Permit Number: 021387

has permission to Expansion of Open Area Near Kitchen

AT 1045 Forest Ave L 146 E009001

Proposed Use: Chinese Restaurant	Proposed Project Description: Expansion of Open Area Near Kitchen
--	---

PROPOSED  
PLOT PLAN FOR 1053 FOREST AVE.

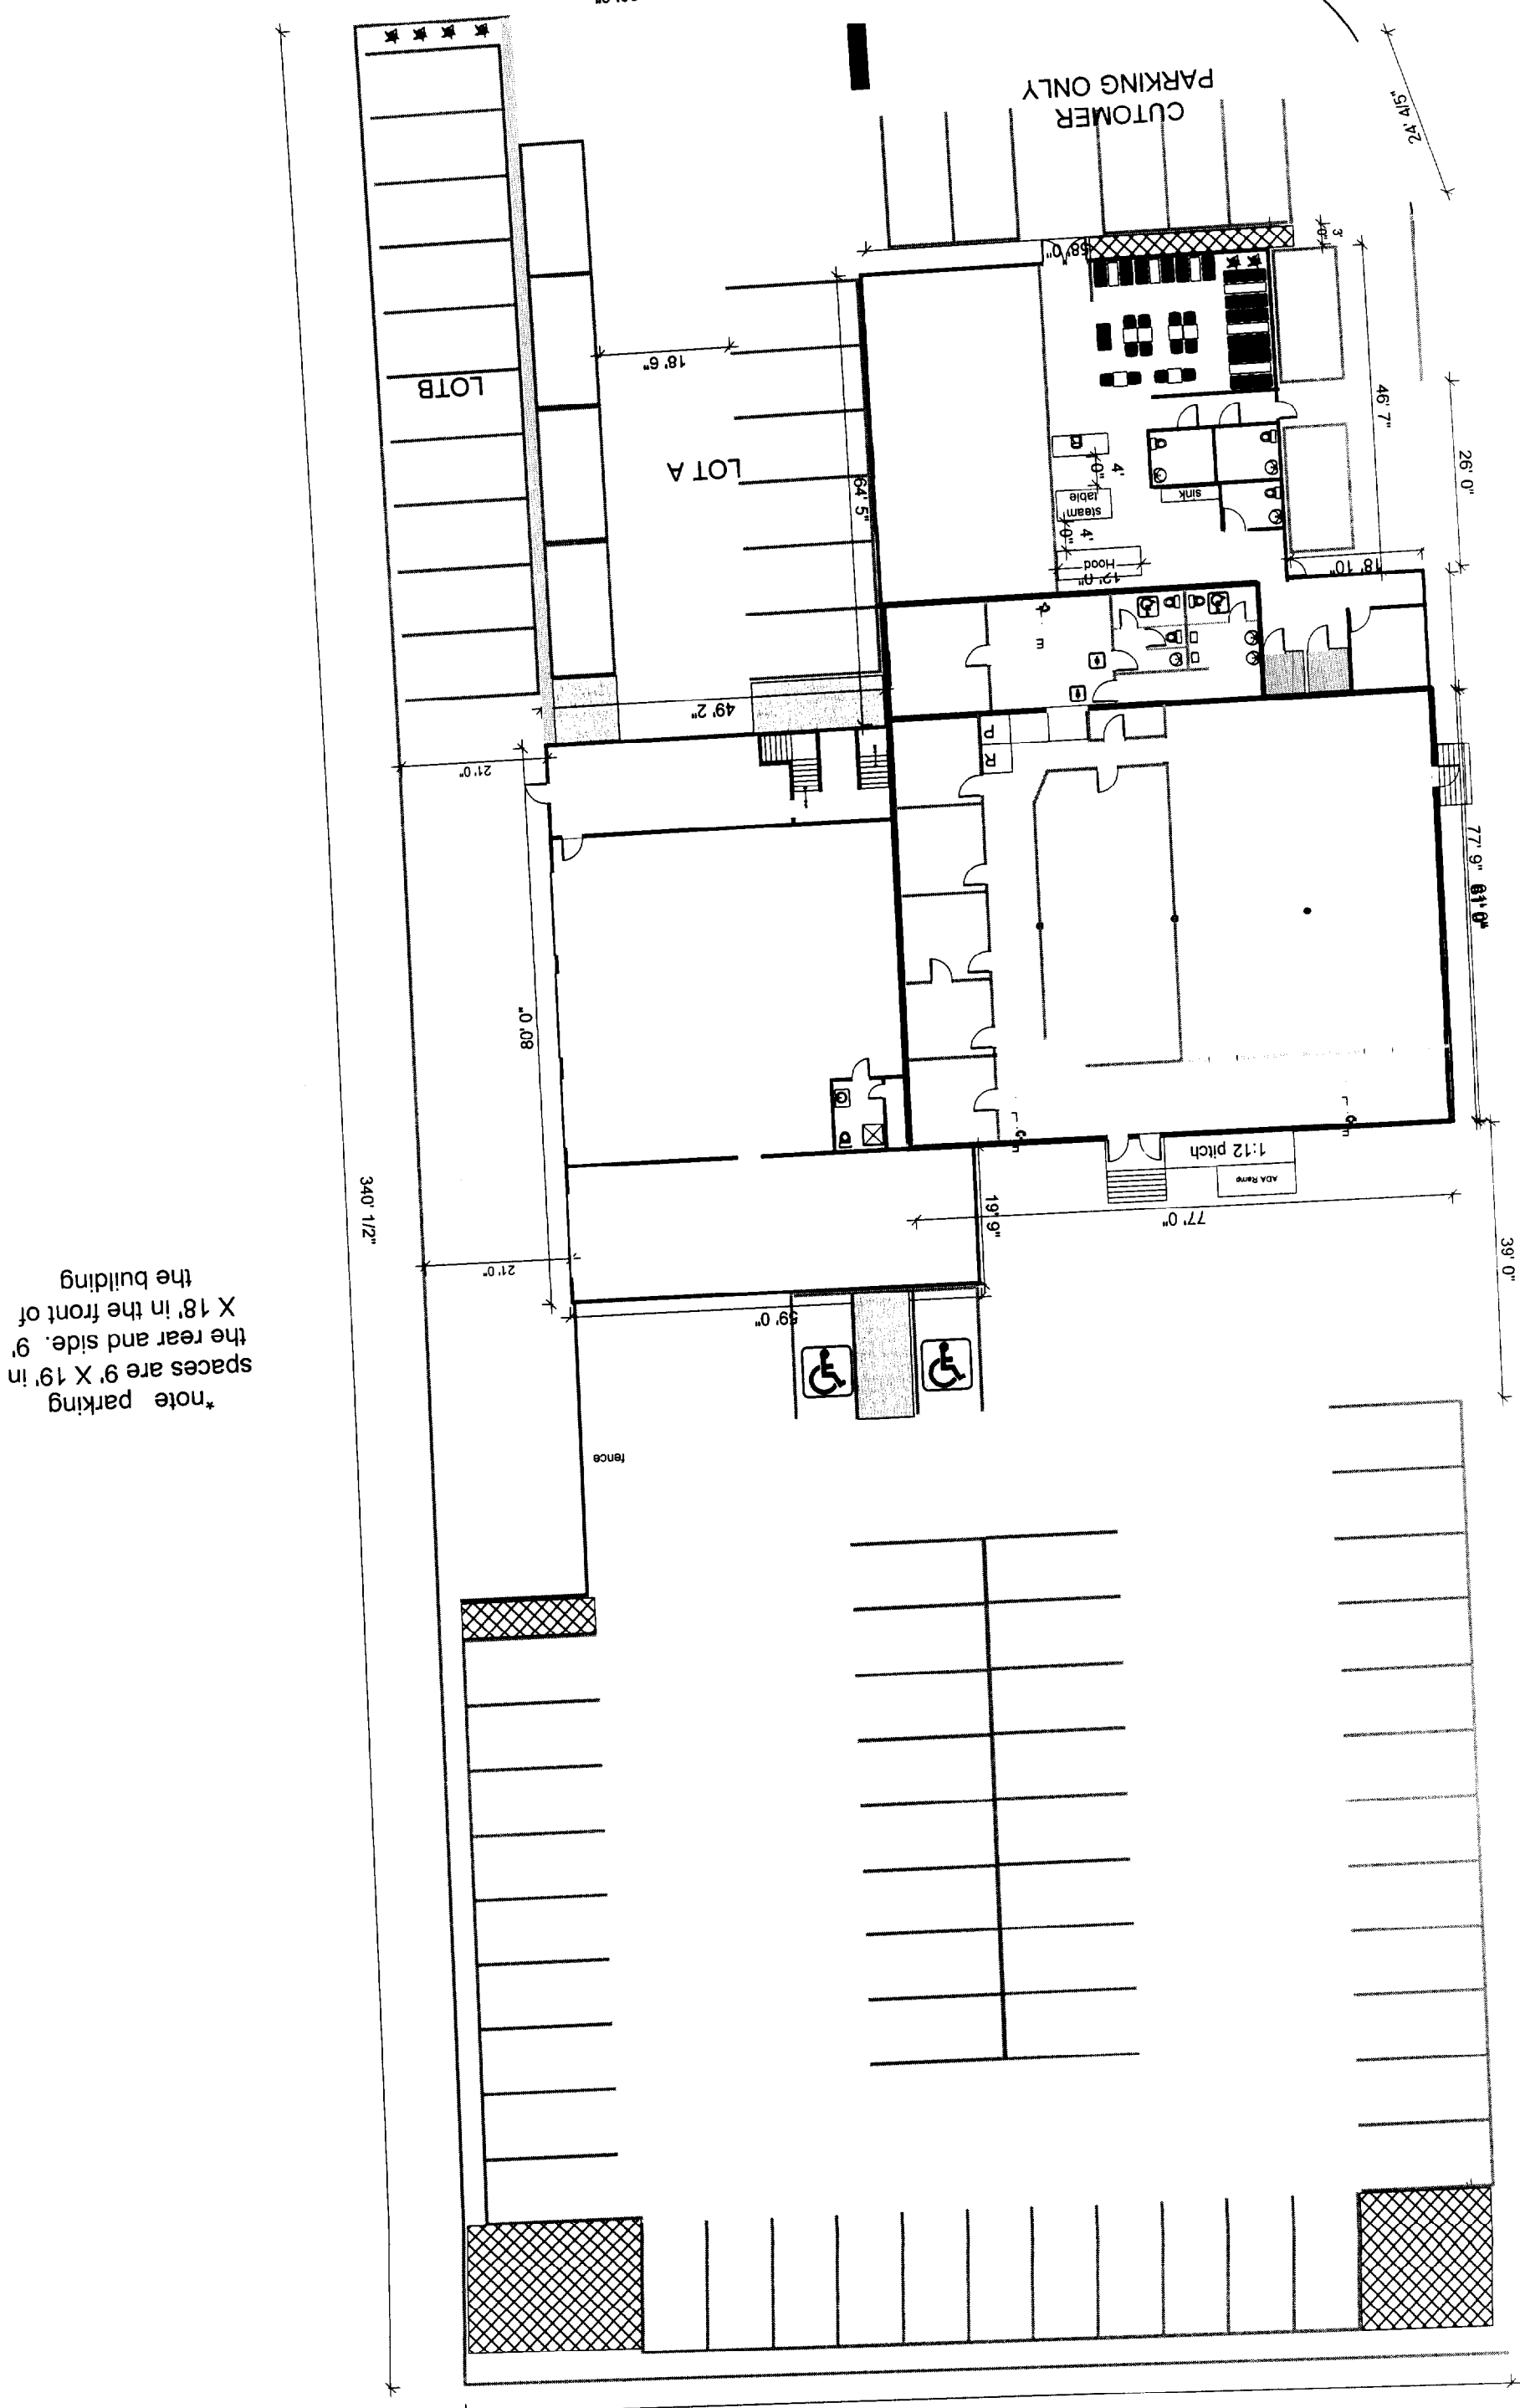
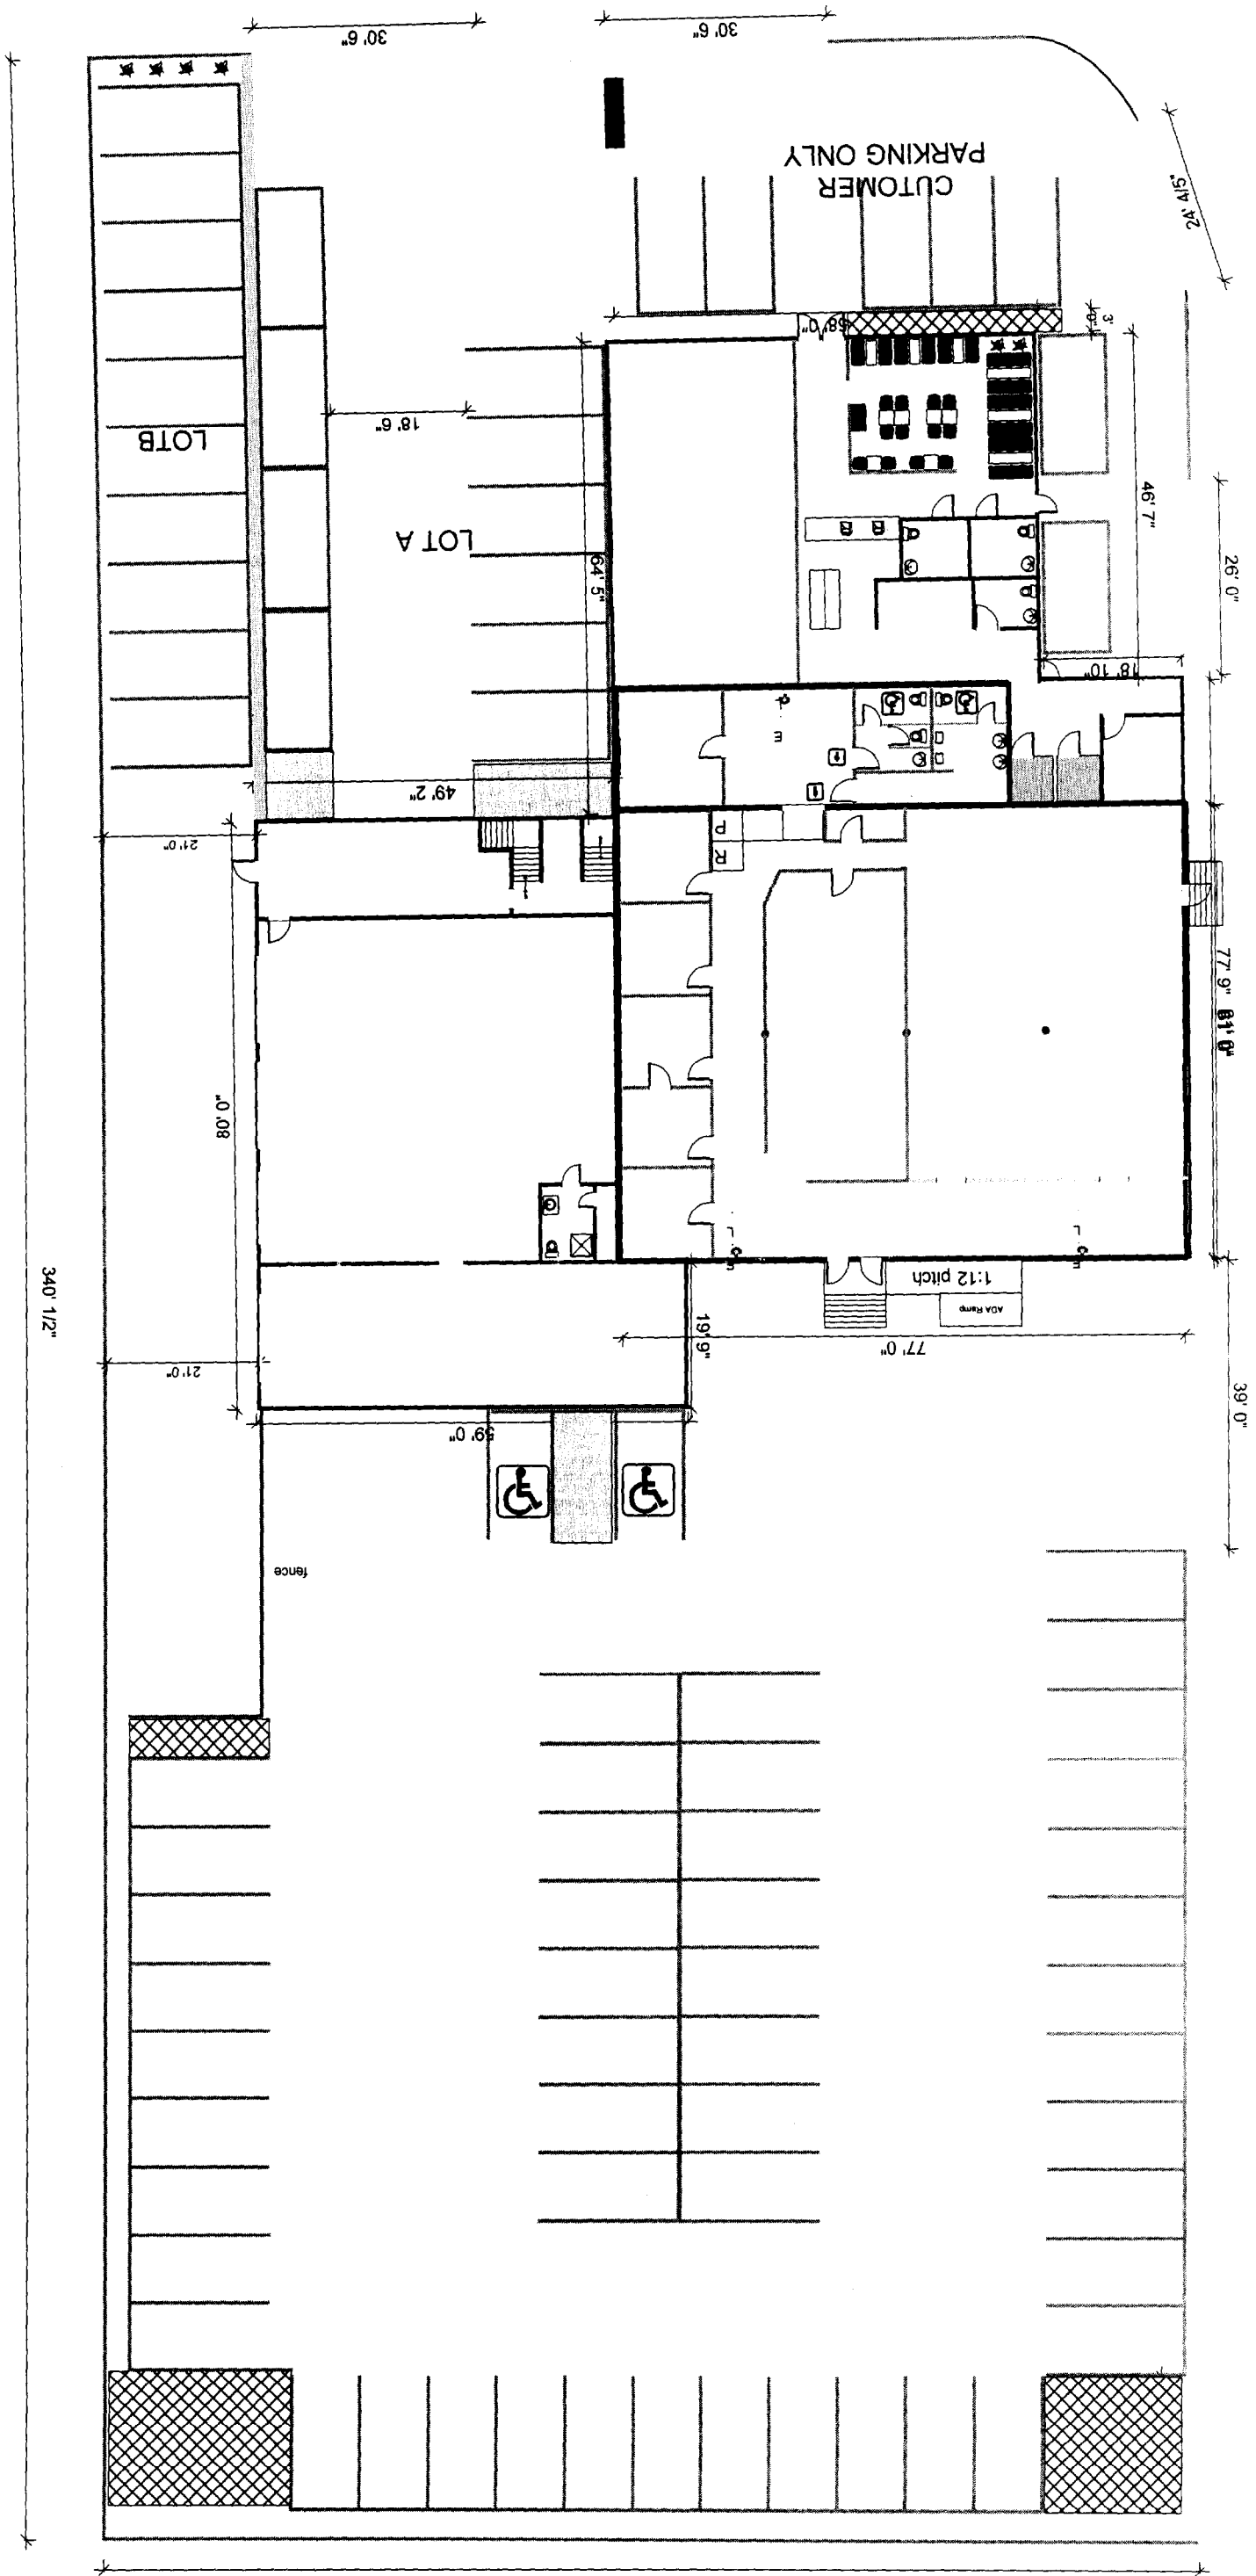
Comments: 12/31/2002-mjn: Need Local Exhaust system details and scaled floor plans to determine occupancy. Owner Notified MJN
